Technical design note

Project name	Nestle Block B		
Design note title	Flood Risk response to LLFA March 2024		
Document reference	C-01669_TN-C-0125		
Author	GJ		
Revision	PO2		
Date	3 May 2024	Approved	<input type="checkbox"/>

The purpose of this technical note is to provide clear responses and supporting information for Hillingdon Planning and Regeneration in regards to flood risk queries from the LLFA concerning Nestle Block B issued on 28th March 2024. The following correspondence has been received by Boyer Planning: -

HYDROCK PROJECT NO. C-01669		SCALE @ A1 1:500	
STATUS DESCRIPTION SUITABLE FOR INFORMATION			STATUS S2
DRAWING NO. (PROJECT CODE-ORIGINATOR-ZONE-LEVEL-TYPE-ROLE-NUMBER) FNF-C-B-HYD-SK-01-901			REVISION P01

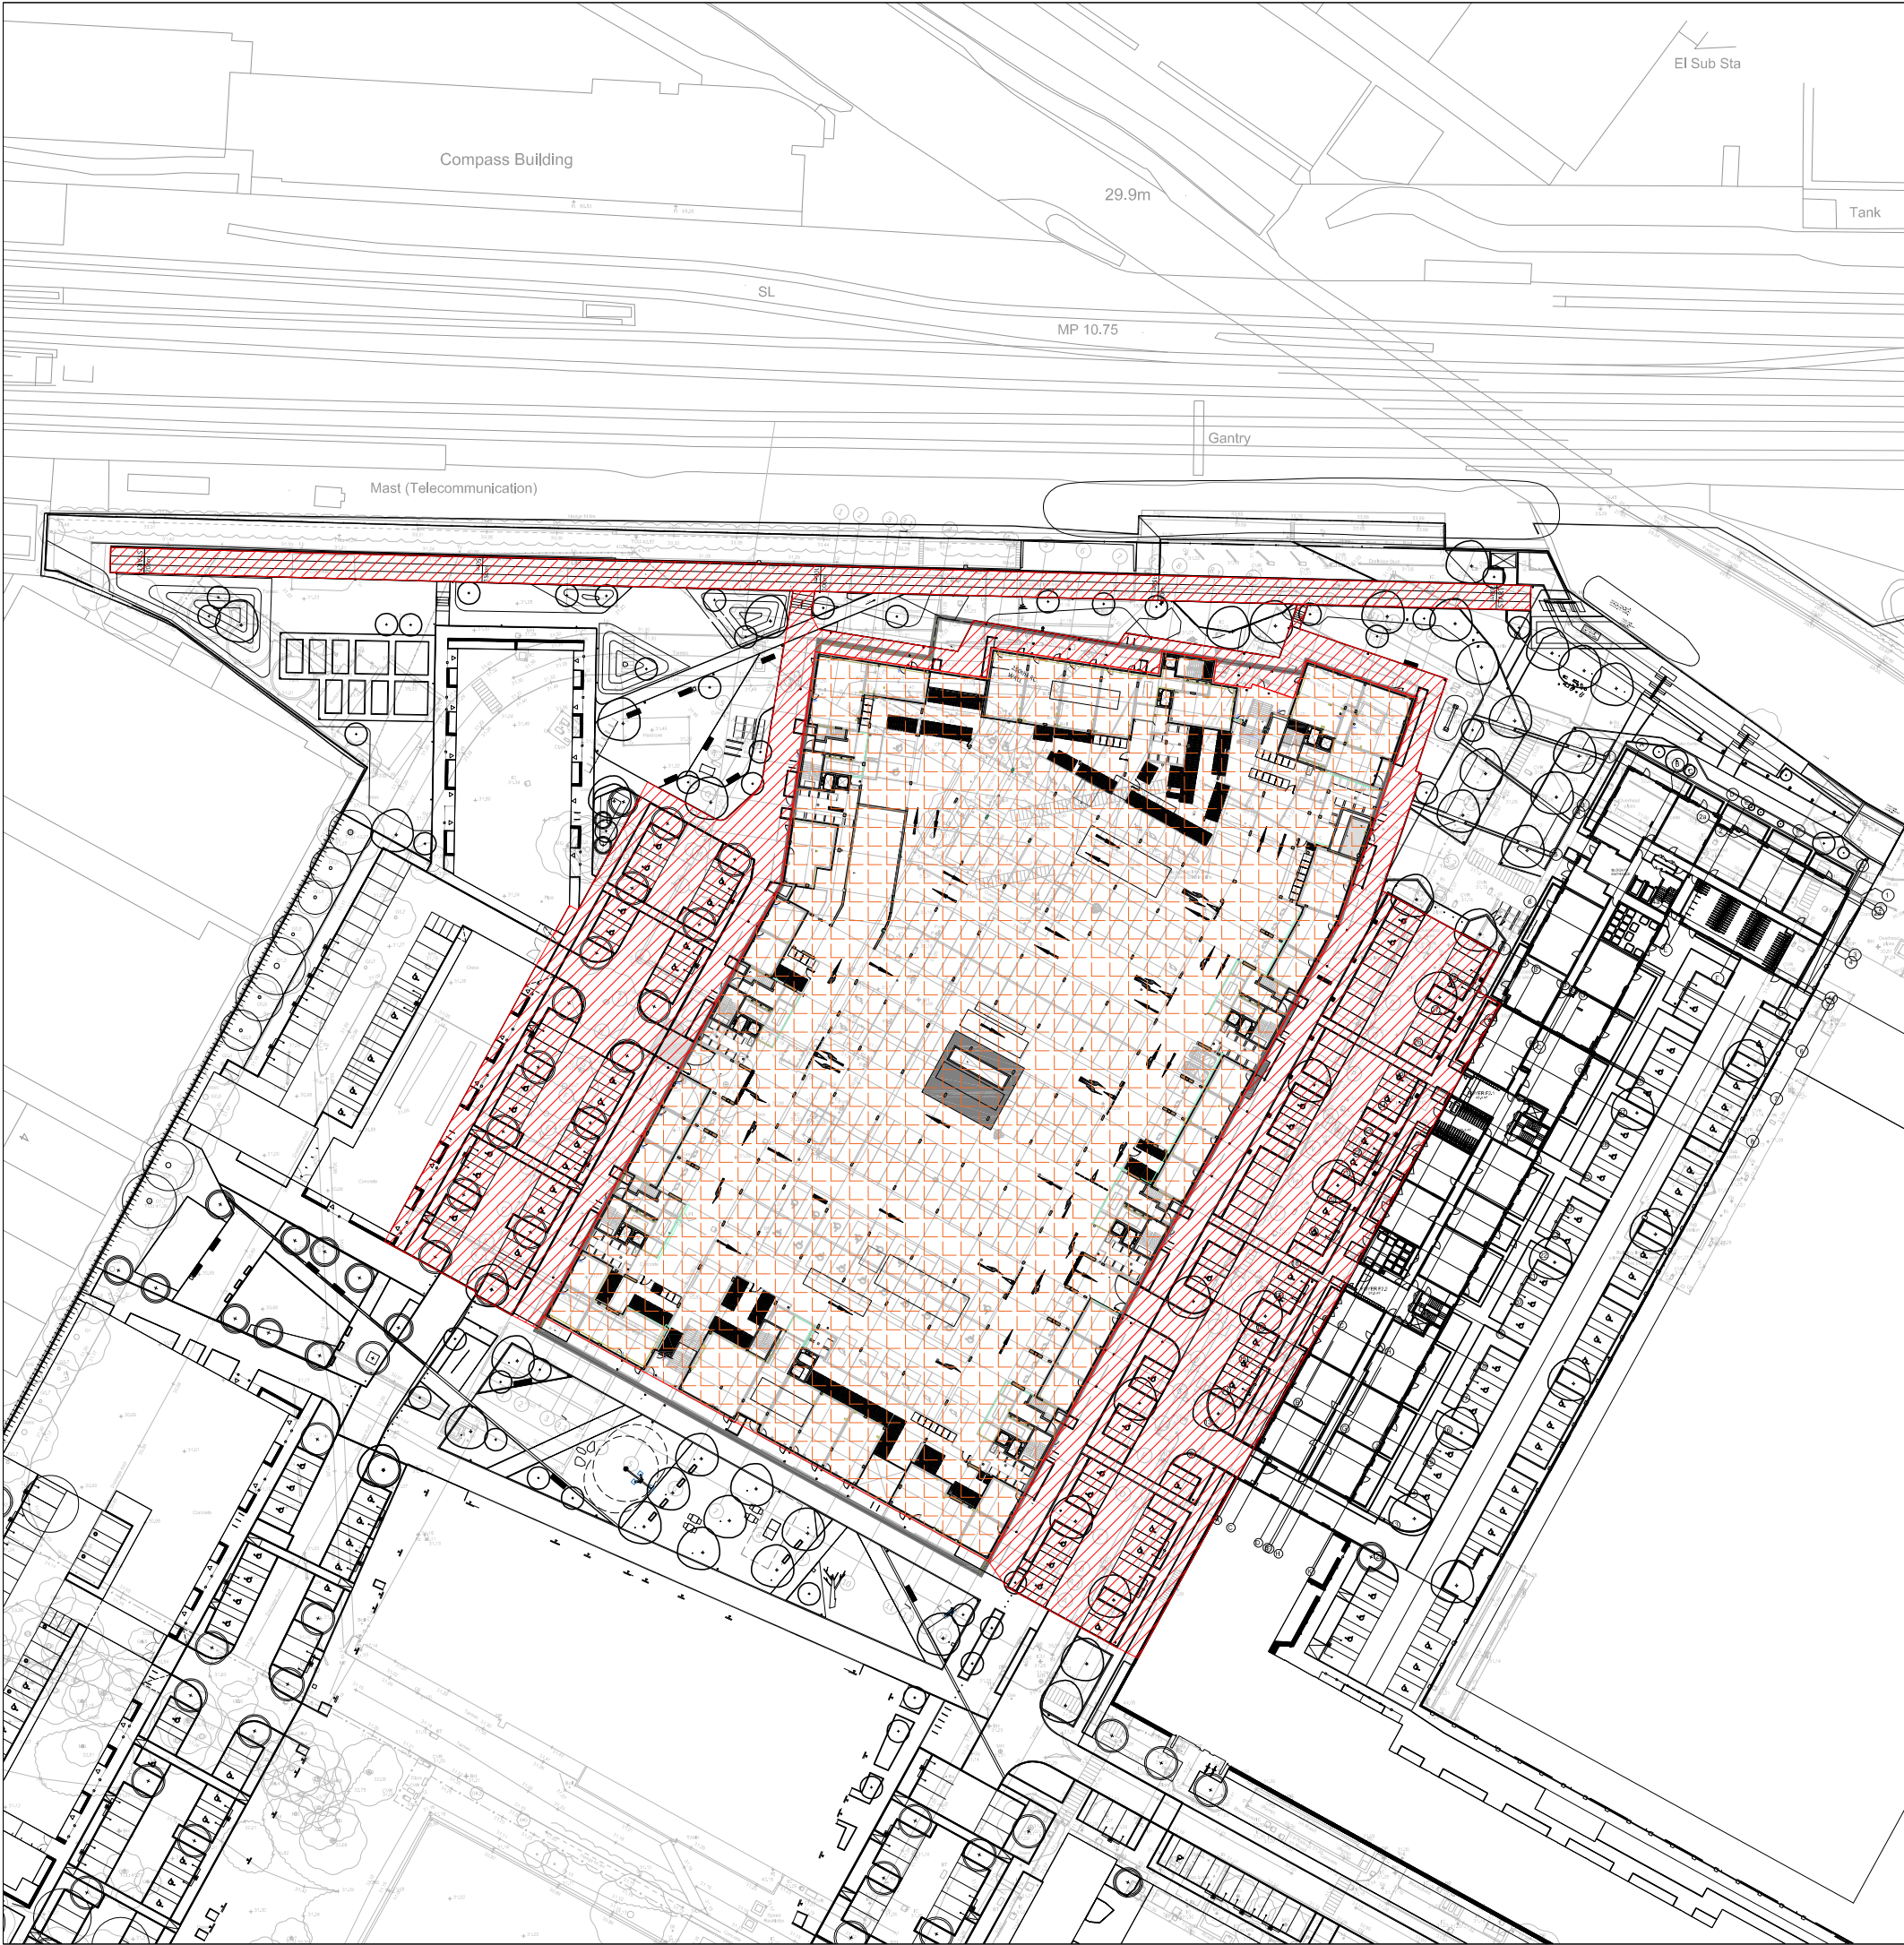
- *MORE INFORMATION REQUIRED – The impermeable areas provided are not consistent throughout the documentation. The applicant should confirm both the total impermeable AND permeable area of the site.*
- *MORE INFORMATION REQUIRED – The applicant has provided updated calculations showing no flooding in a 1 in 100 year plus climate change event. However, the calculations do not incorporate the whole of the Block B development area.*

The total existing impermeable catchment area within Block B site area is shown on drawing FNF-C-B-HYD-SK-01-0101 P01 Rain water catchment area. Refer to Appendix A.

- External impermeable areas = 2,783 m²
- Building roofs (Blue Roofs) = 5,037 m²
- Podium B = 4,713 m²
- Permeable paving = 2,543 m²
- **Total area captured by positive drainage = 15,076 m²**
- Verges = 2869 m²
